**CHERWELL DISTRICT COUNCIL**  
**TOWN AND COUNTRY PLANNING ACT 1990**

Appeal by Mr Rowland Bratt against the decision by Cherwell District Council to refuse planning permission for the erection of garage adjacent to approved dwelling and change of use of agricultural land to residential use at Barn and Land South West of Cotefield Farm Church Street Bodicote.

Appellant	:	Mr Rowland Bratt
Appeal Site	:	Barn and Land South West of Cotefield Farm Church Street Bodicote
Appellant's Agent	:	Mr Roger Coy Roger Coy Partnership 32 Lime Avenue, Eydon DAVENTRY Northamptonshire NN11 3PG
LPA Reference	:	20/00841/F
PINS Reference	:	APP/C3105/W/20/3263029

DRAWING NUMBER:  
**4728/22F**

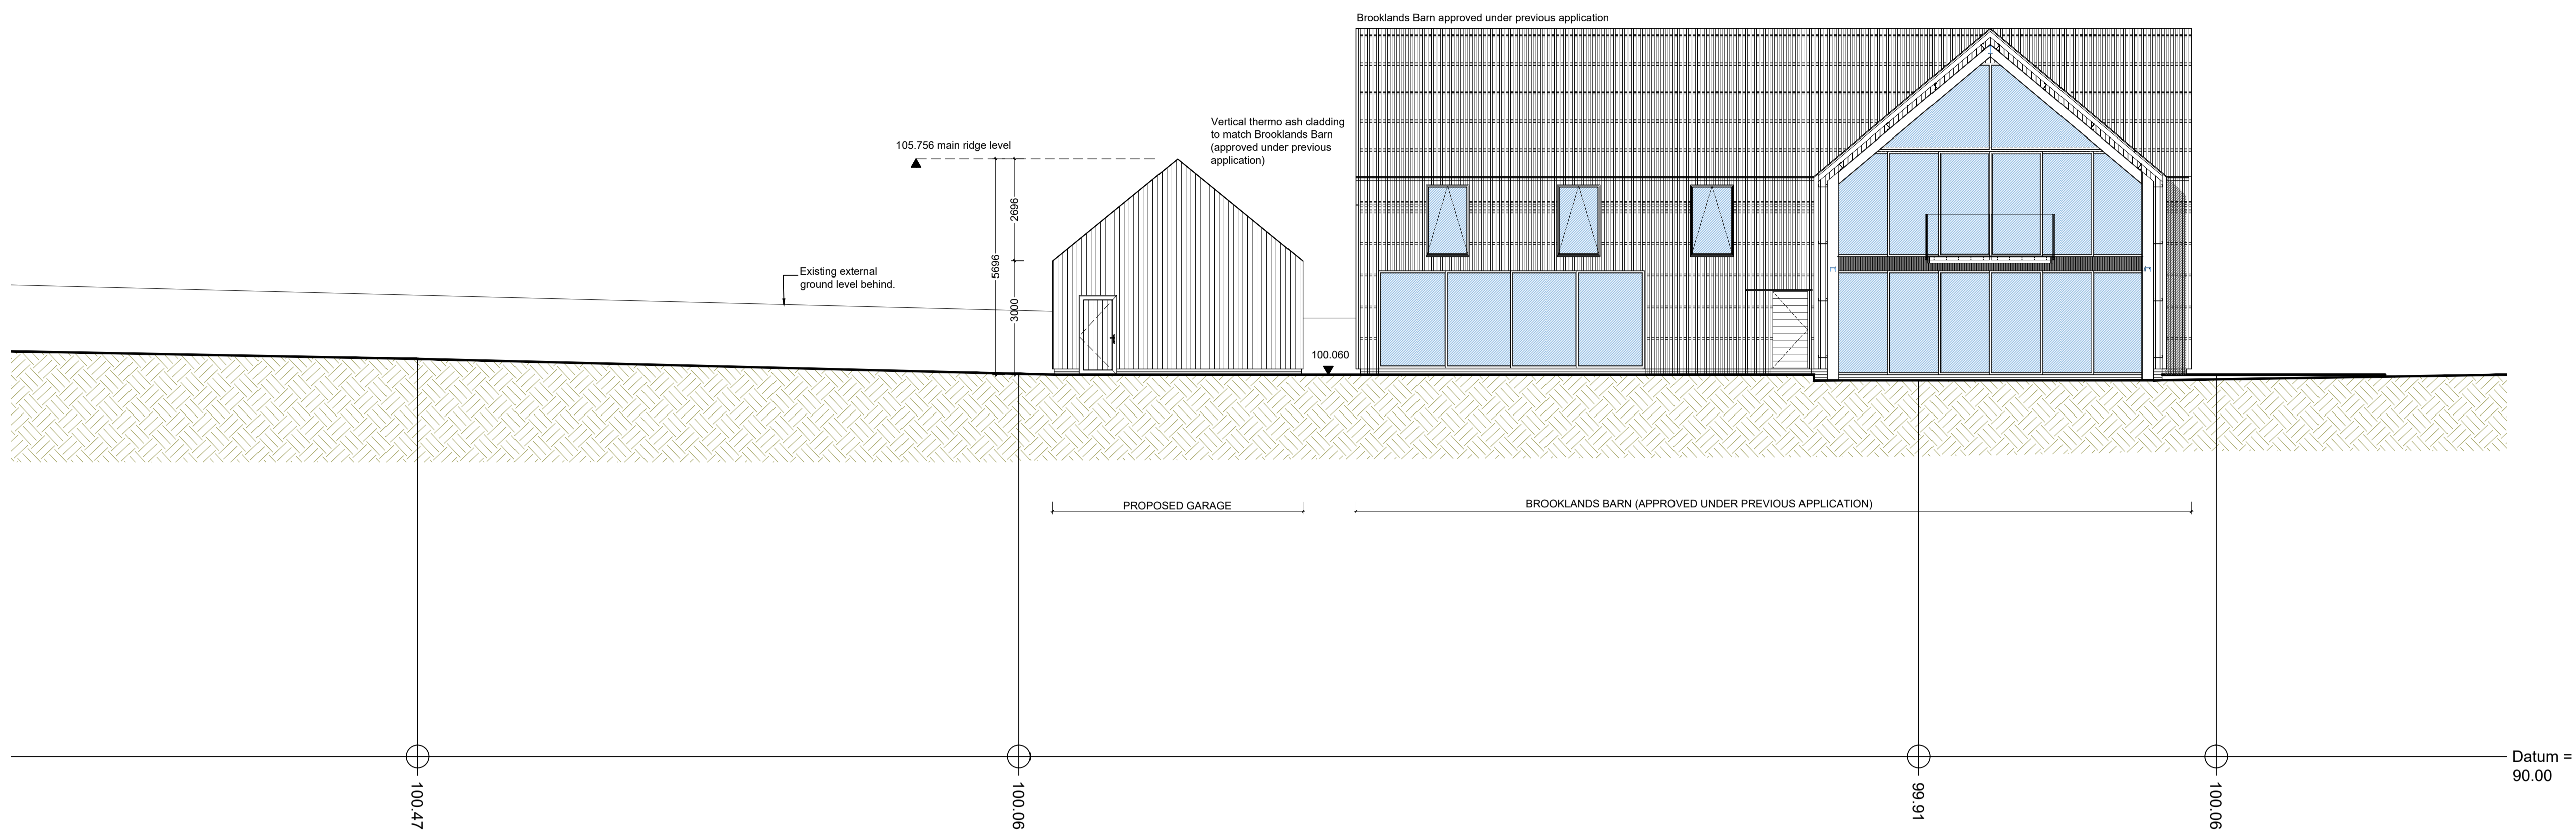
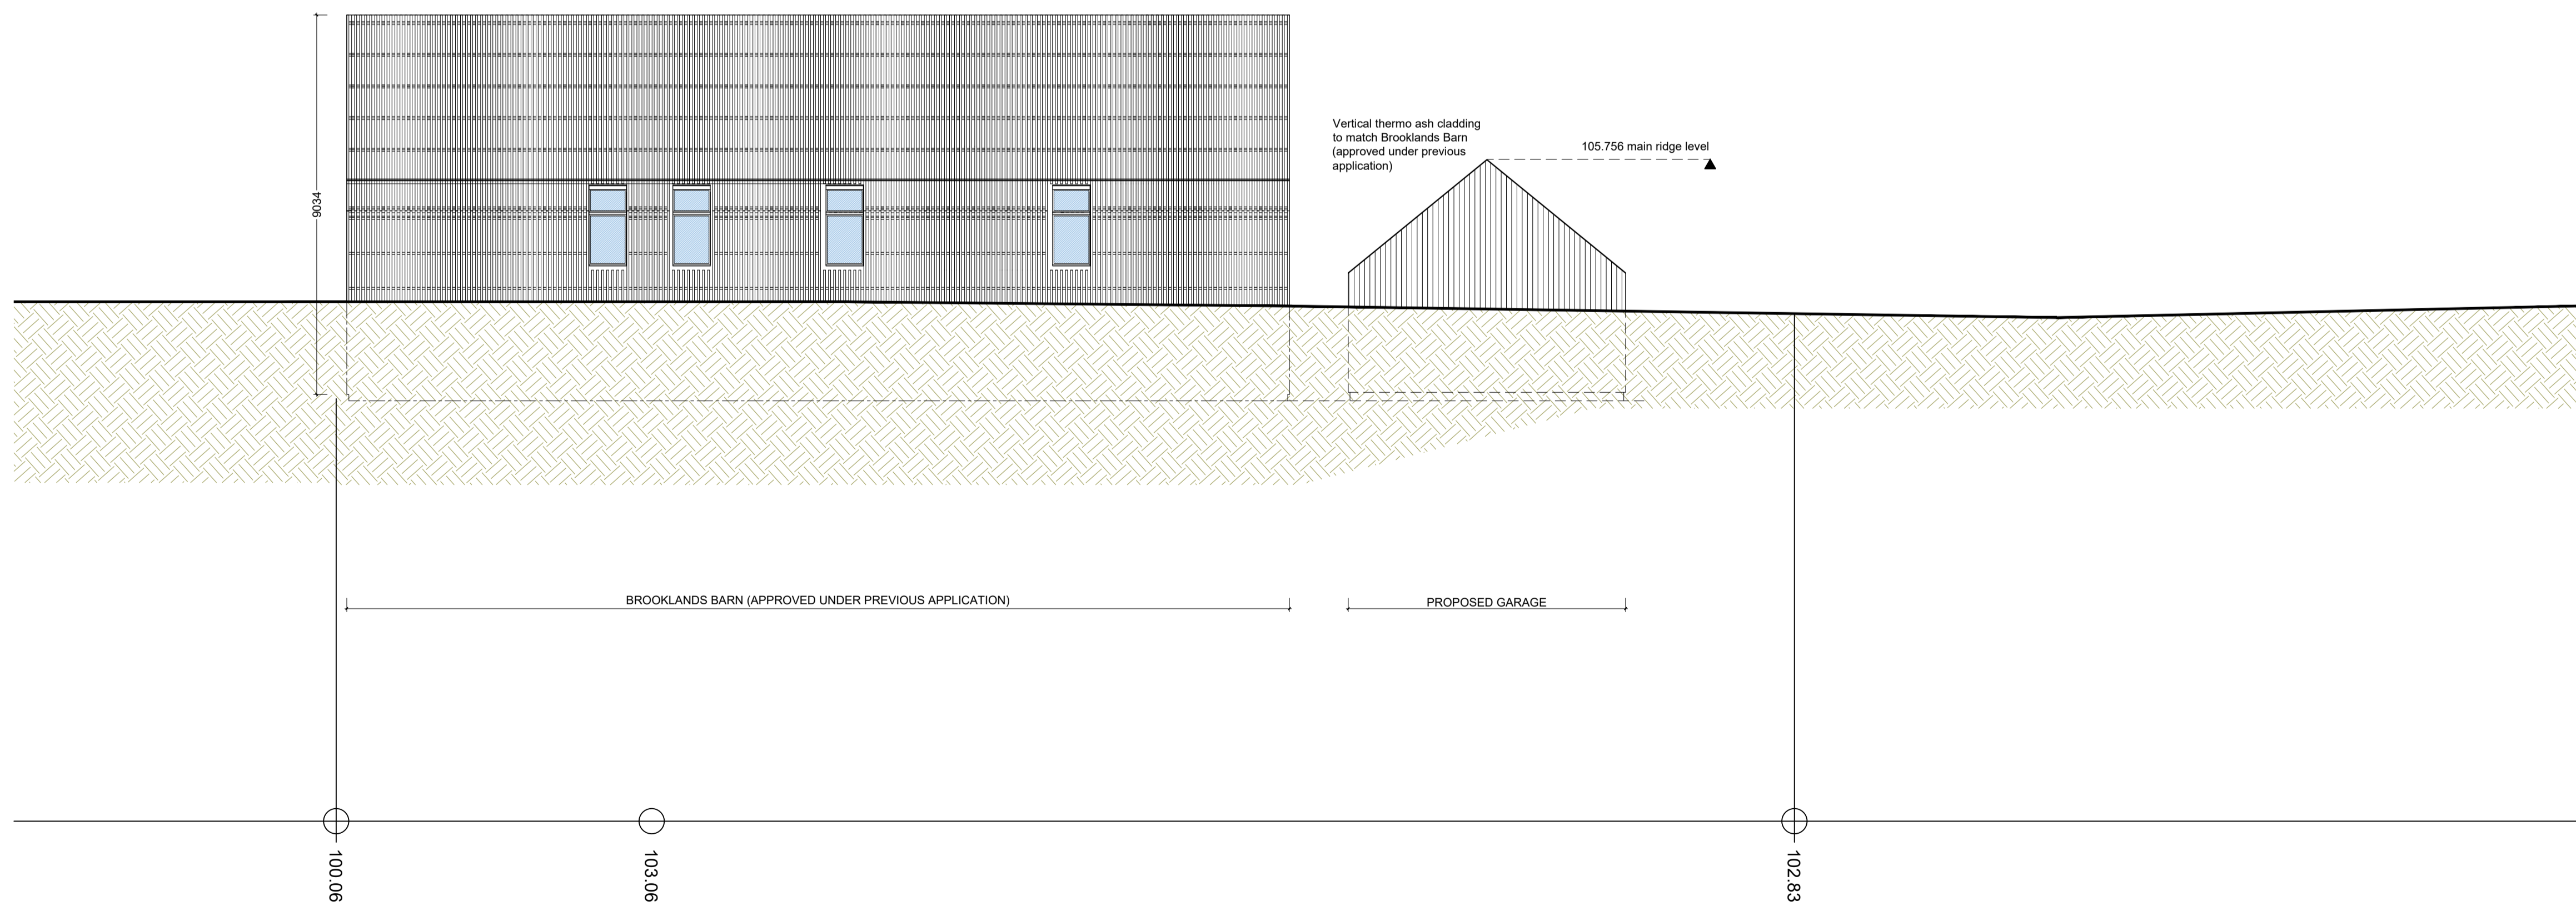
- 2.4 In respect of the development approved under 20/01767/F the Council remains of the opinion that the siting of the approved garage is far more sympathetic to the context,

requiring less alteration of the existing landform (whereas the appeal proposal requires significant excavation works being set into the natural slope of the site) and would be less visually intrusive benefiting to a far greater extent from screening of the new dwelling and being set in a lower position (approximately 1.5m lower) within the site.

- 3.3 The Council considers that by virtue of its inappropriate scale, design and siting within the rural landscape, the proposed garage, associated hardstanding and expansion of residential land use, from that previously approved under the original consent, would fail to reflect or reinforce local distinctiveness or the rural context, intruding out into the open countryside; causing significant and demonstrable harm to the character and appearance of the area.
